***MODIFICATION REQUEST:  
Mixed Use Development, 330 Church  
Street, Parramatta  
MP 10\_0171 MOD 3***

Director-General's  
Environmental Assessment Report  
Section 75W of the  
*Environmental Planning and Assessment Act 1979*

November 2013

PROJECT	
RIVERFRONT APARTMENTS 330 CHURCH STREET PARRAMATTA NSW	
DRAWING NAME	
Plan_Level 01 Podium

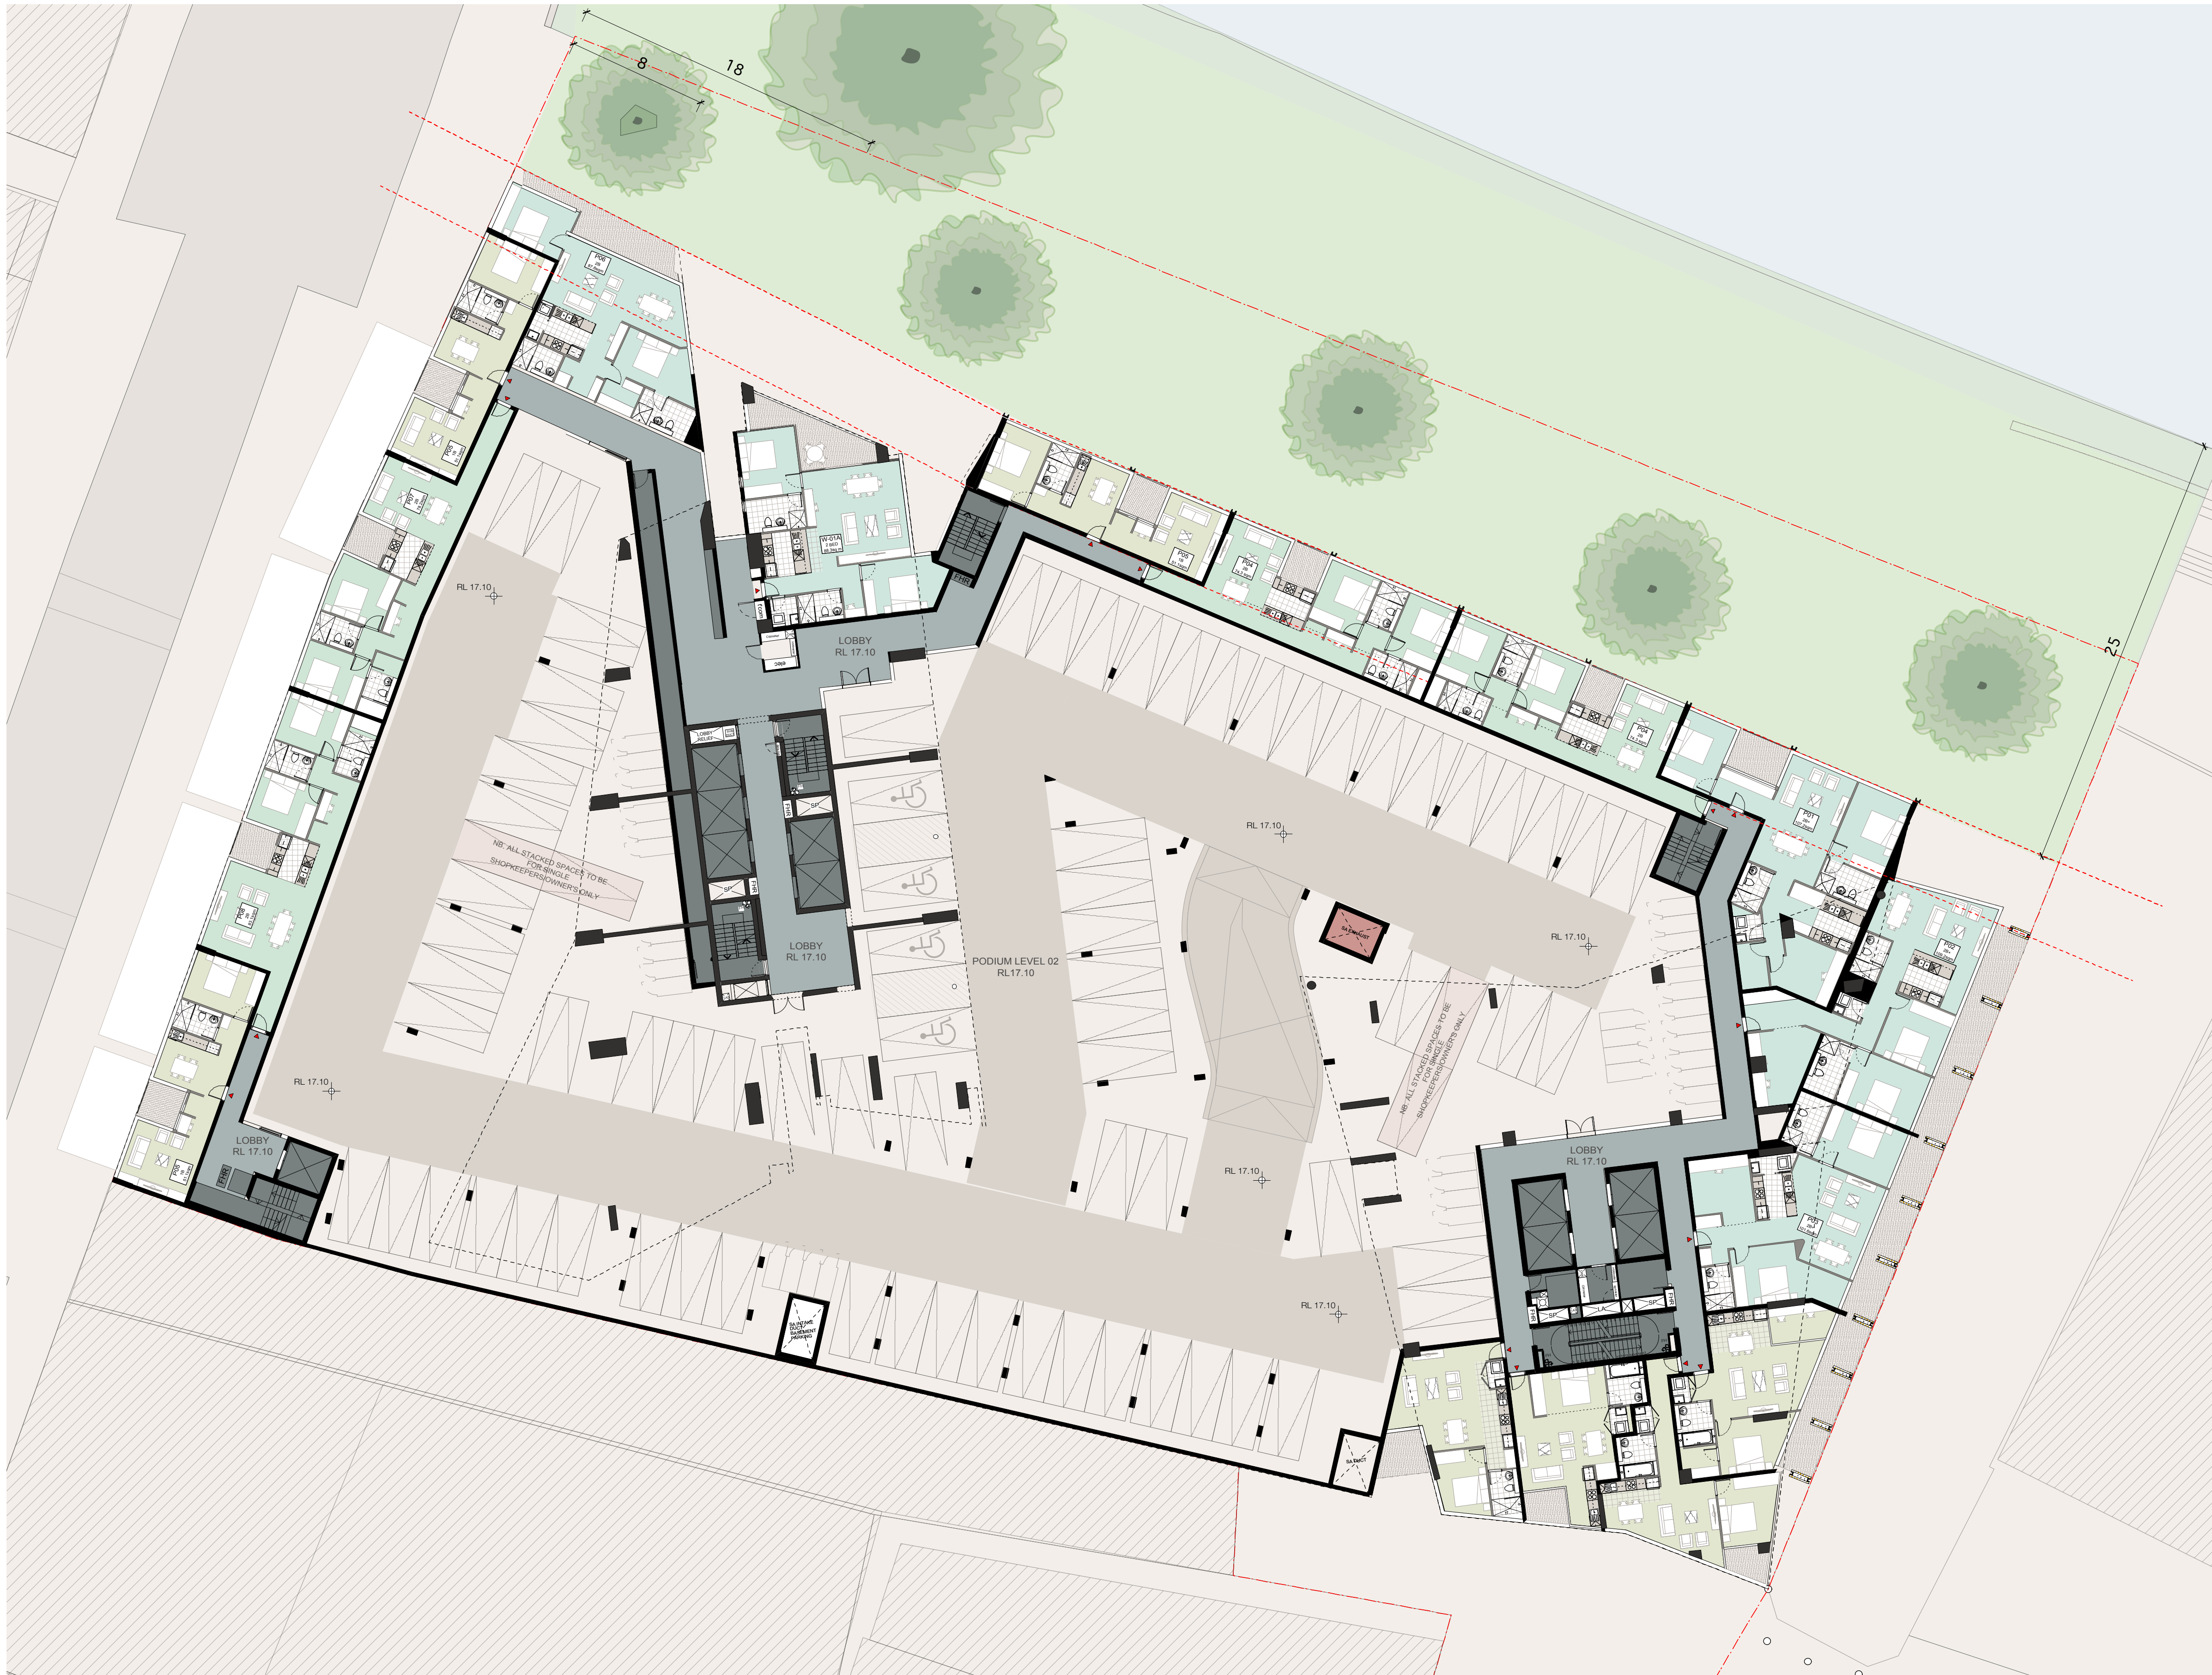
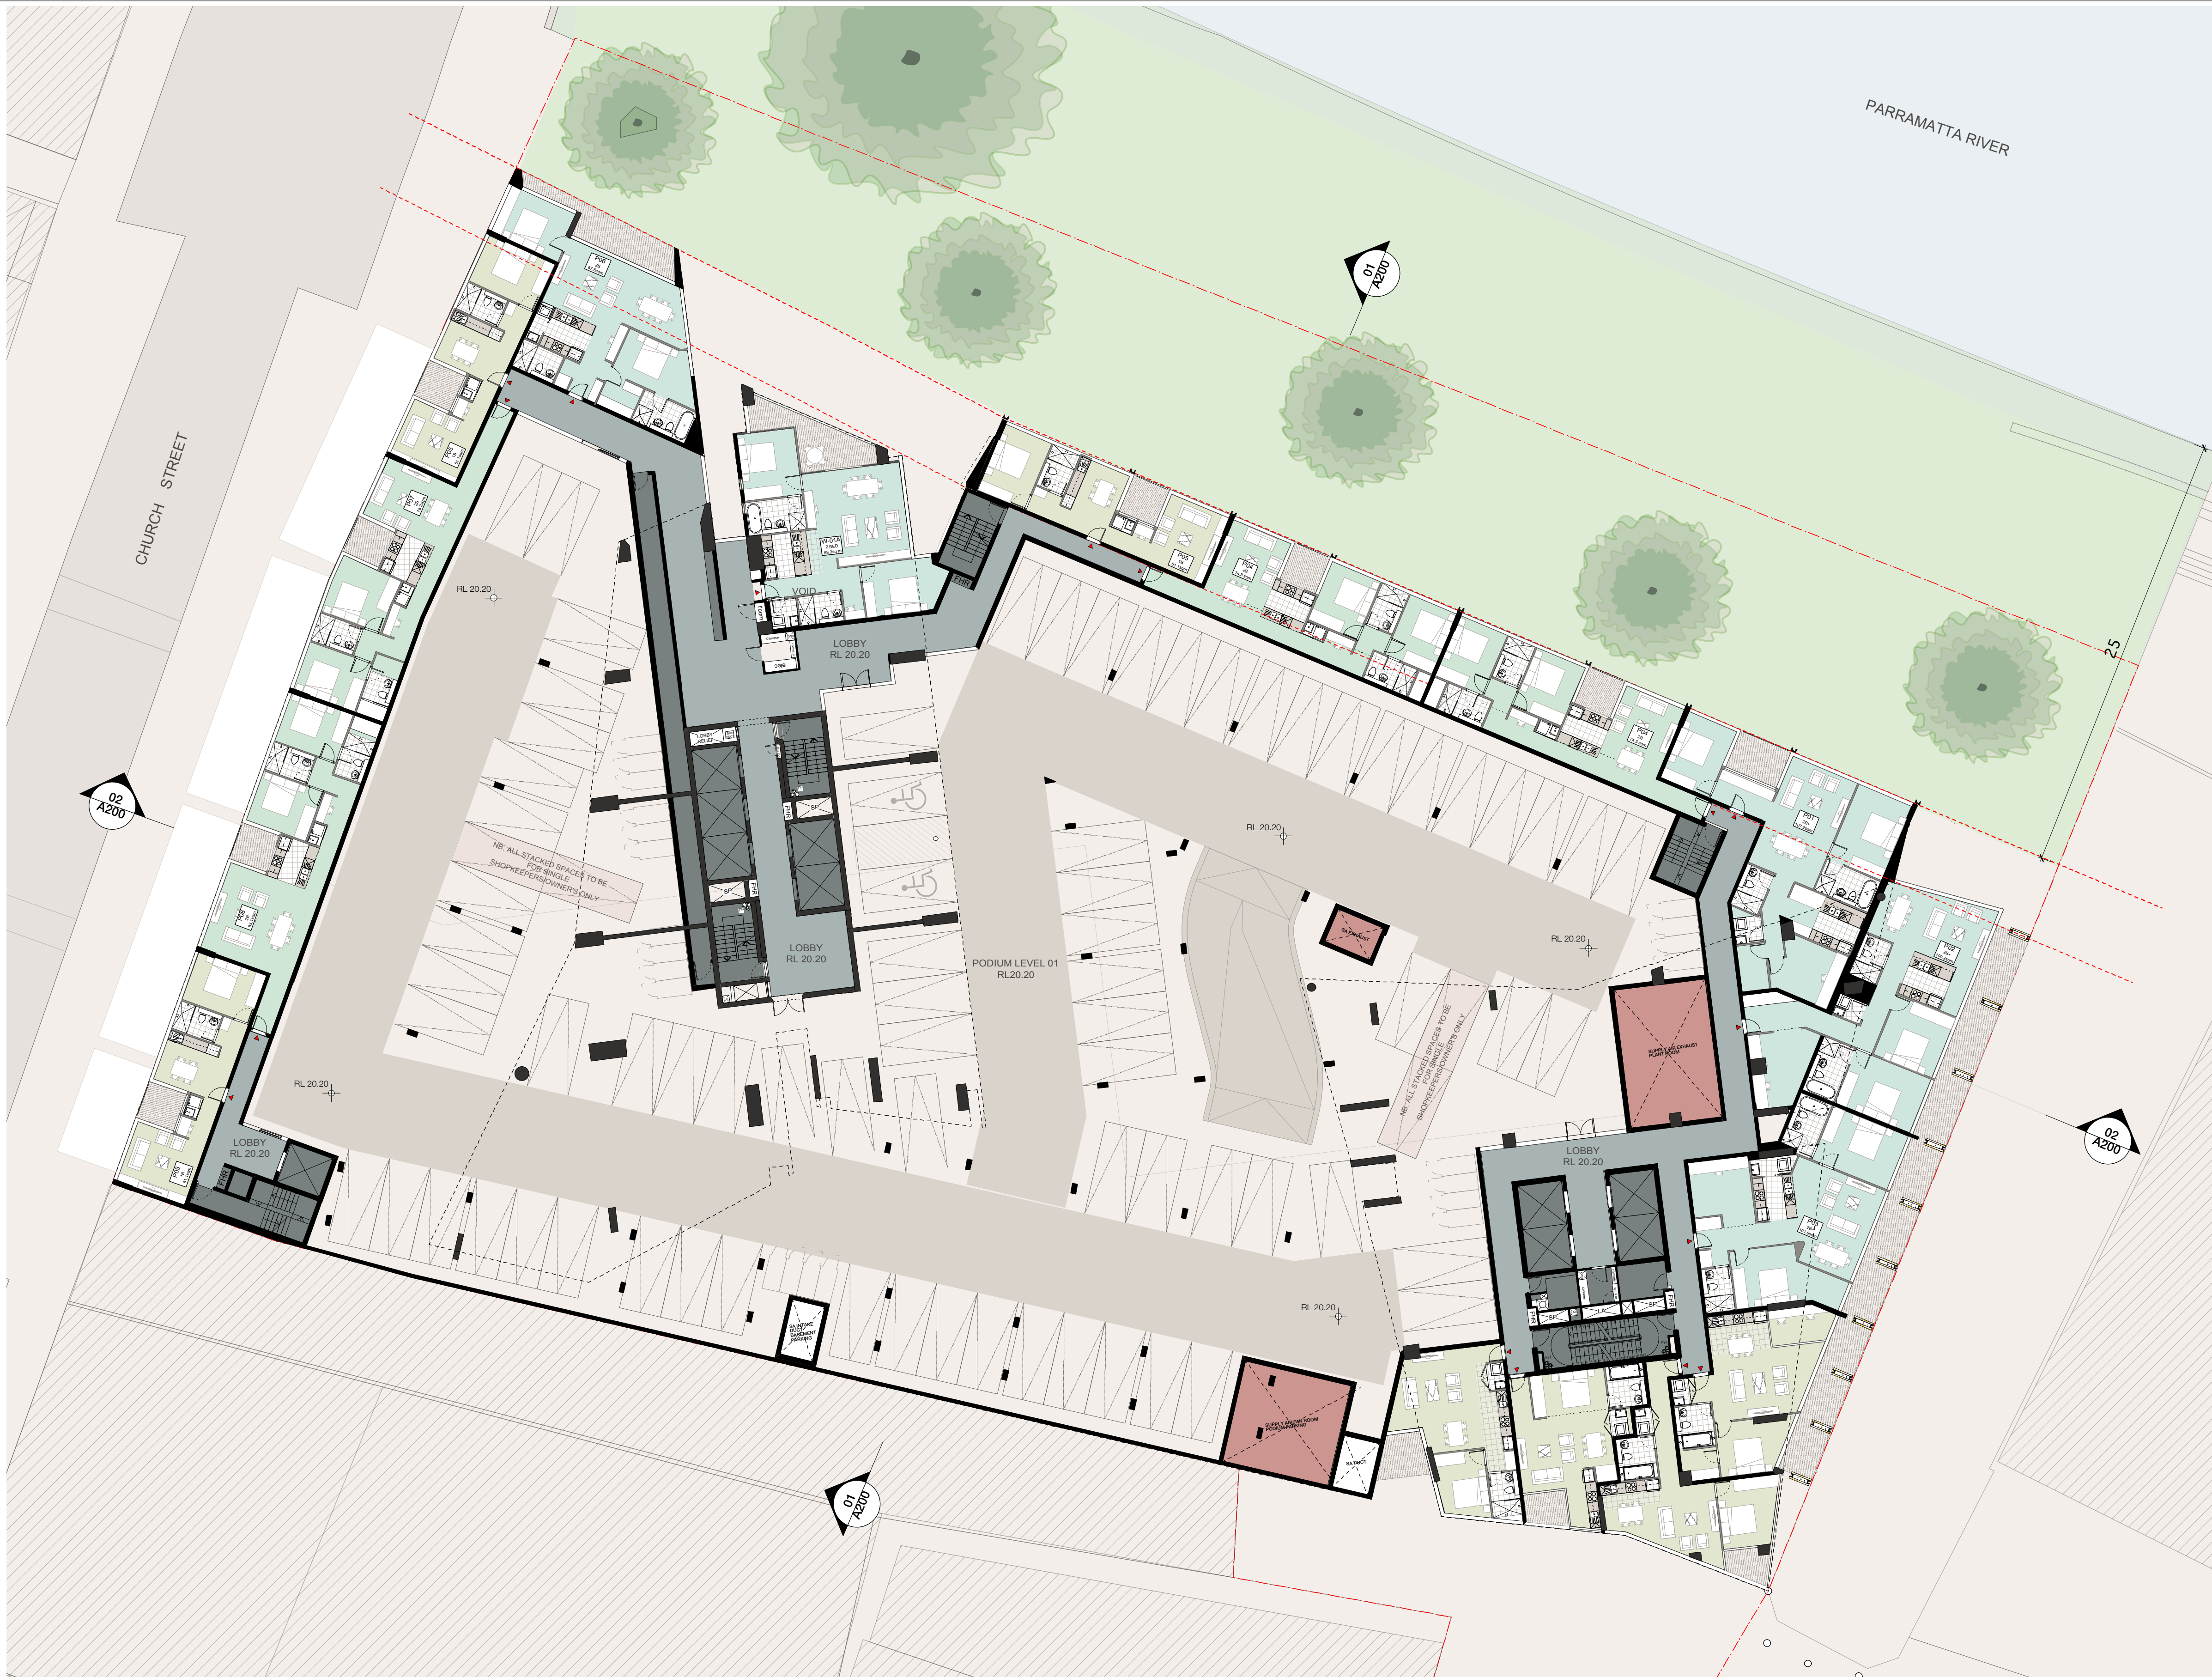
- Some of the apartments located within the podium have compromised amenity, particularly in relation to natural ventilation;
- All apartments that share a common wall with the podium level car park should be provided with appropriate acoustic treatments; and
- All balconies should comply with the *Residential Flat Design Code*.
